# ENG-PUDSP19005-R4b-TIS-Redlines Summary\_Markup Summary

Figure 4

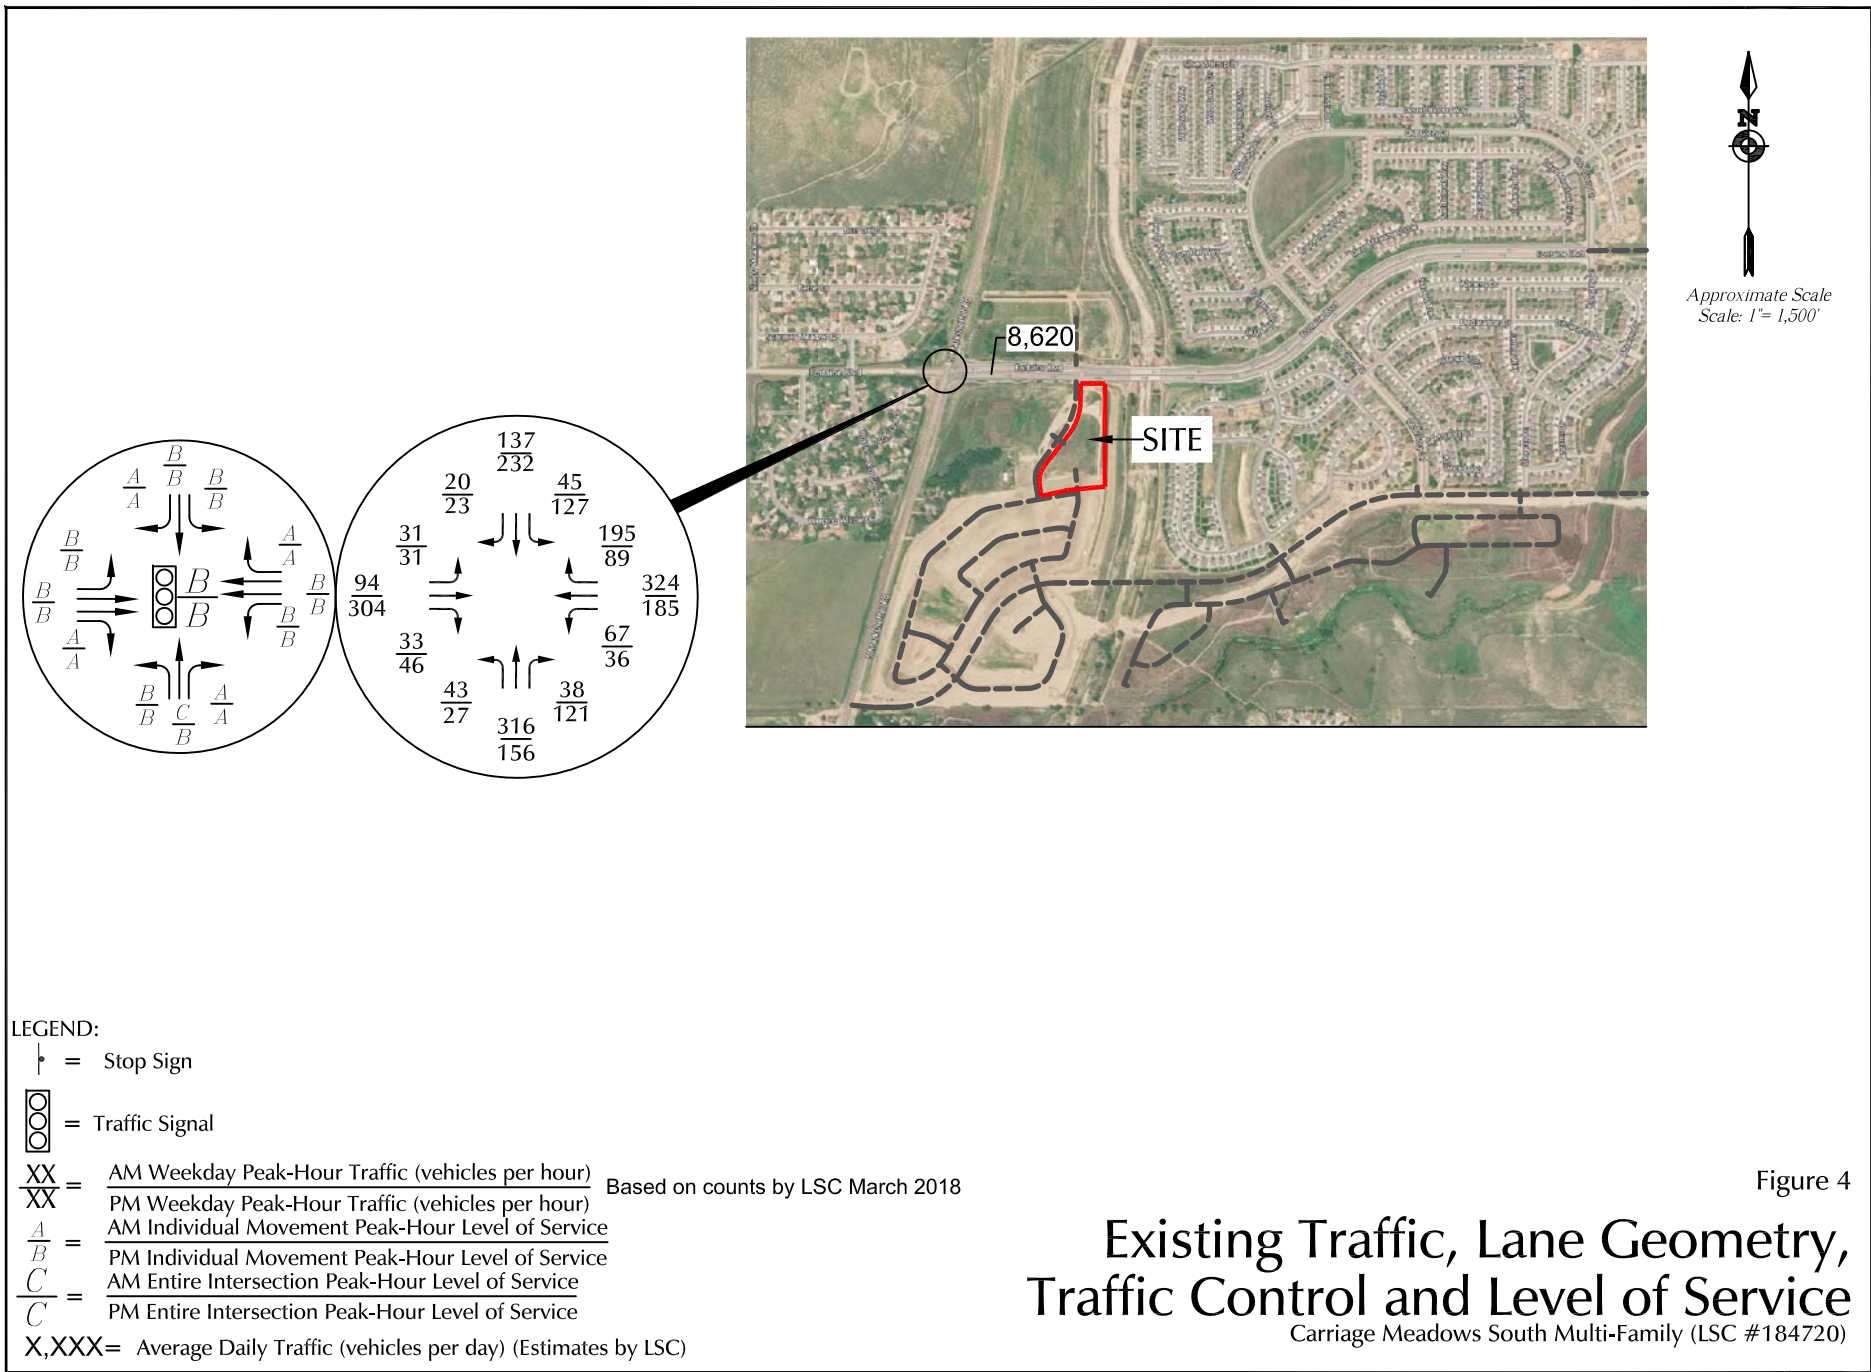
§ the proposed public road, station drive, line  
) between Firesteel Drive (public) and Tolt Trail  
interline to centerline of each road.  
roadways closer than 175 feet from each other  
Address sight distance at  
these roads. (see Figure 3)

Address sight distance at these roads. (see Figure 3)

STREETS DETAILS

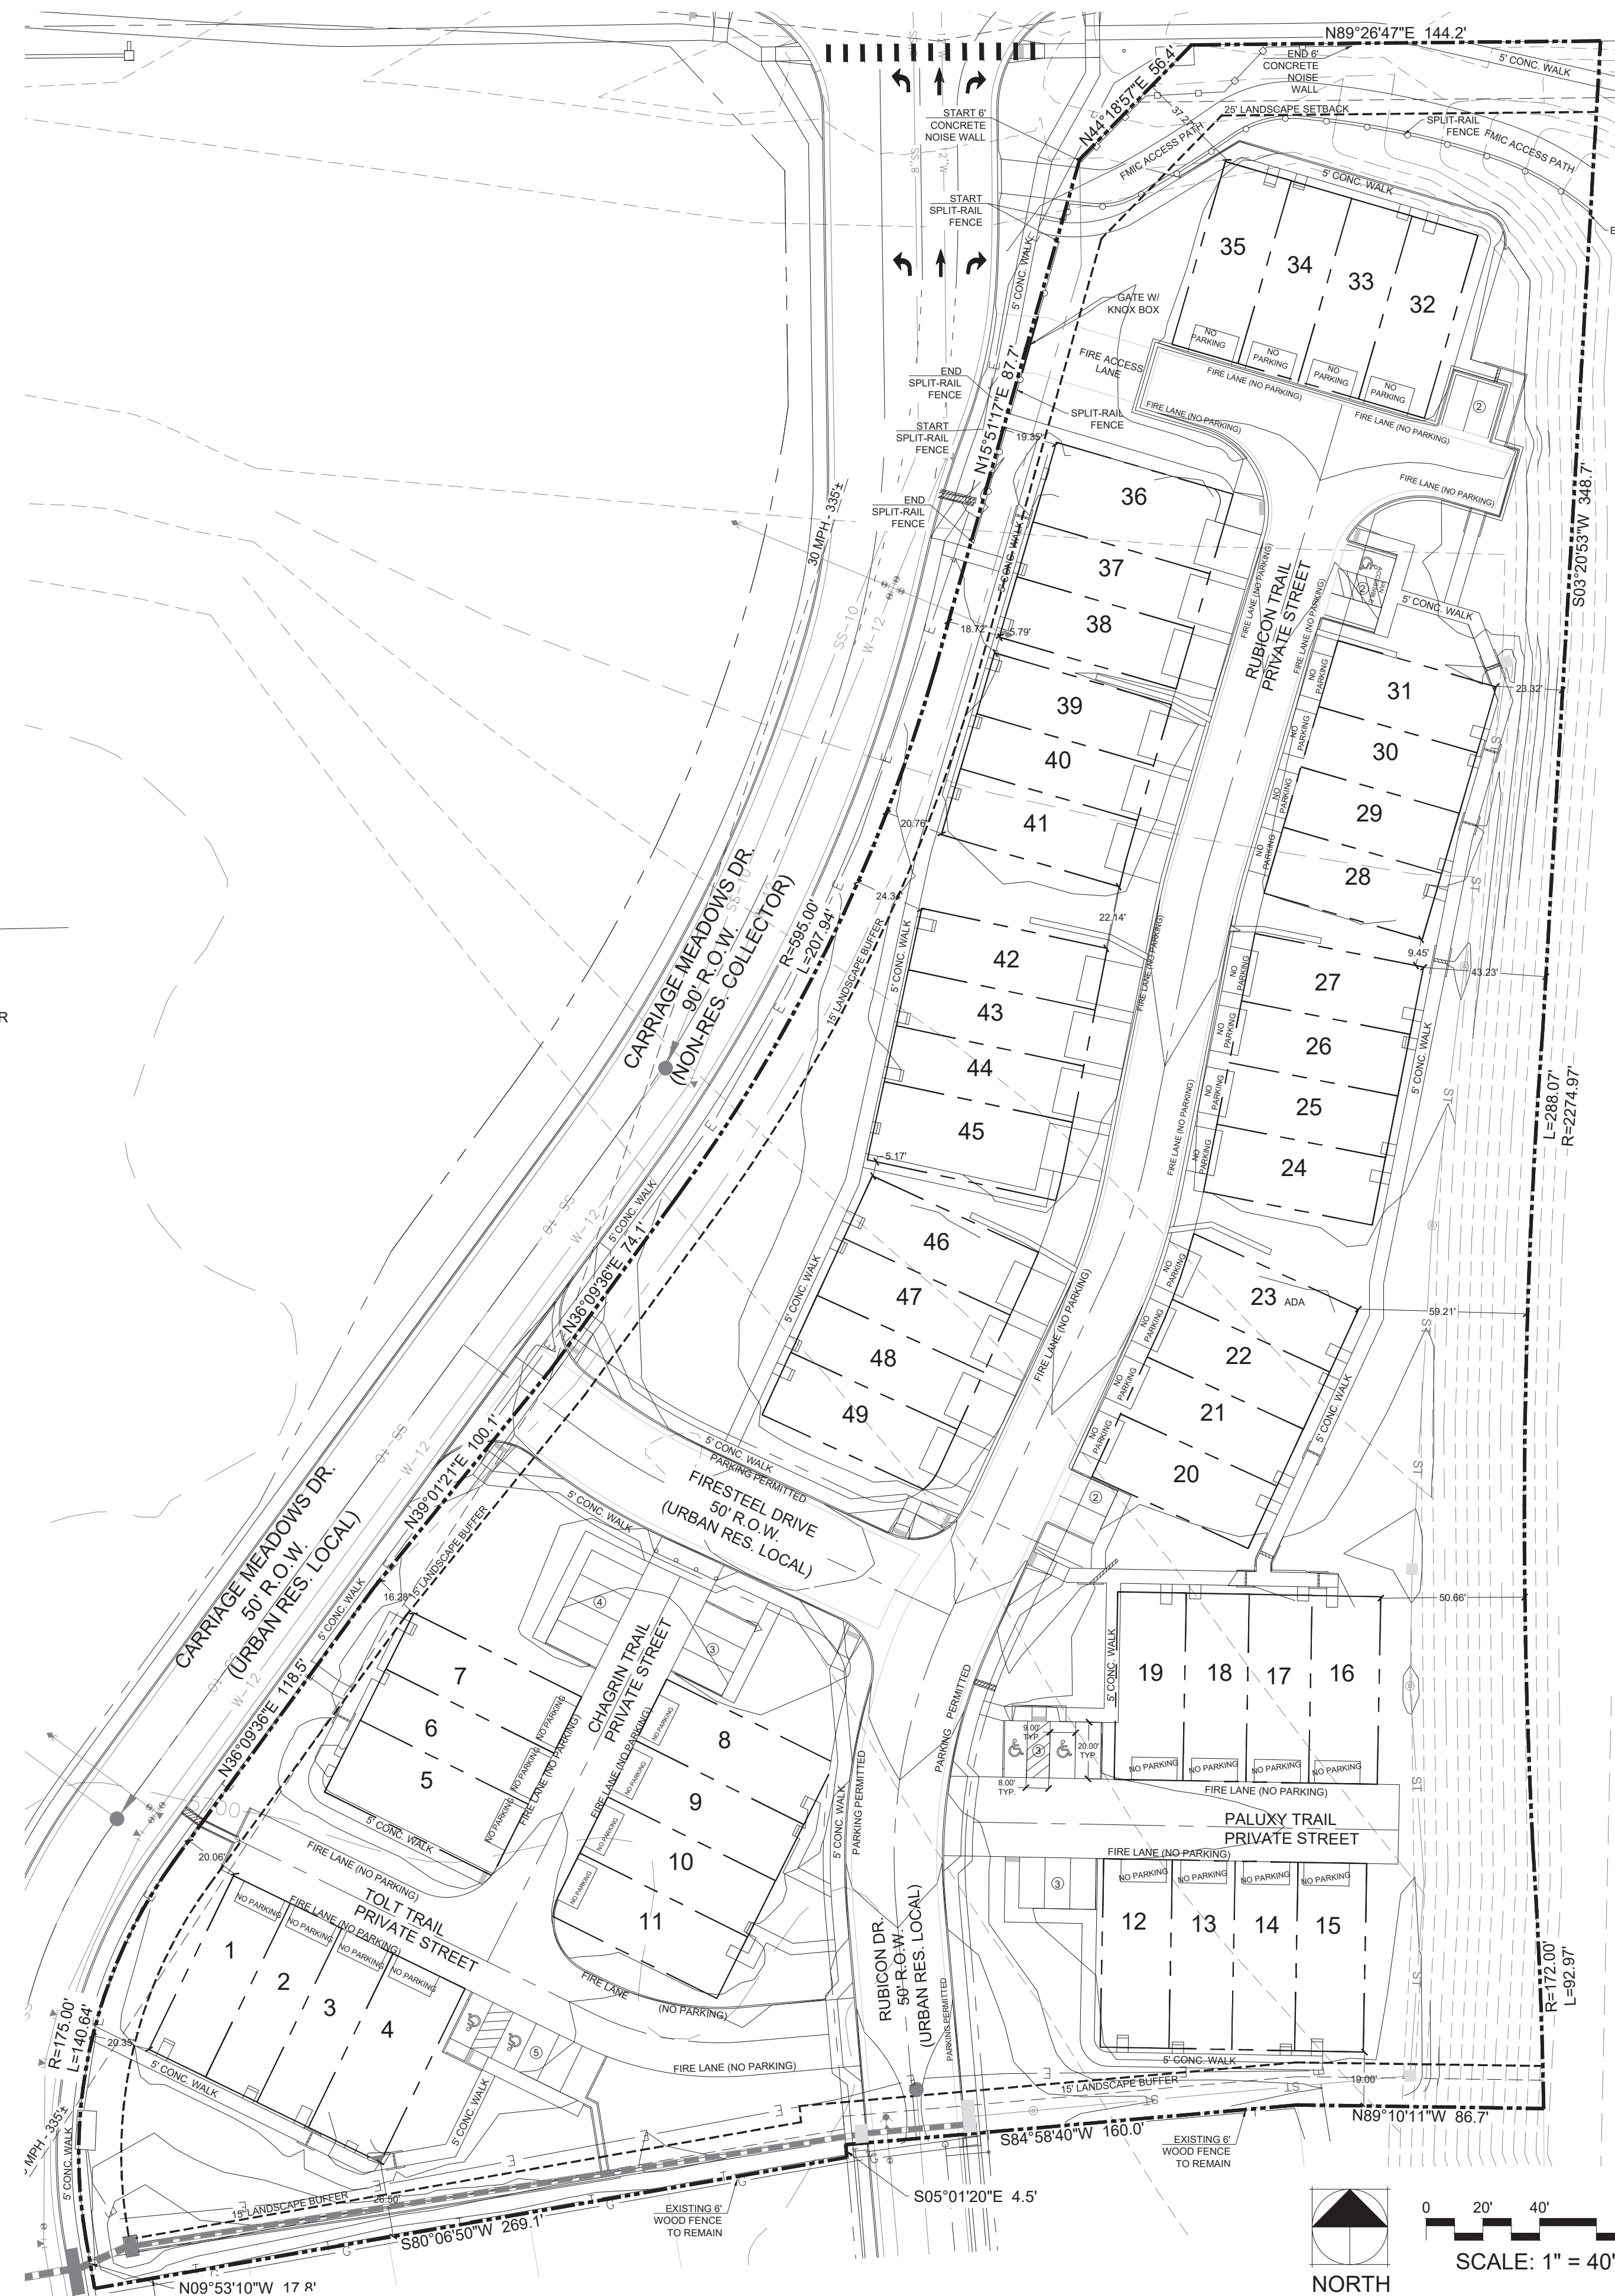
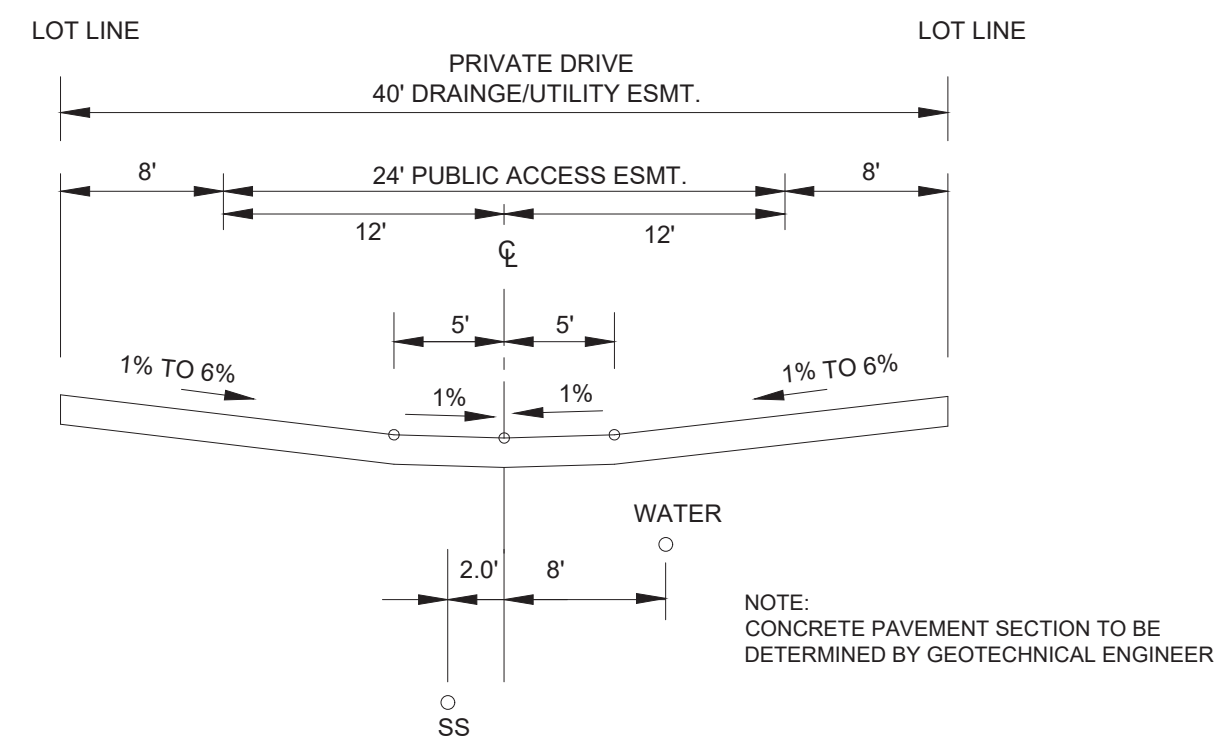
Show curb & gutter

Clarify striping in highlighted areas.
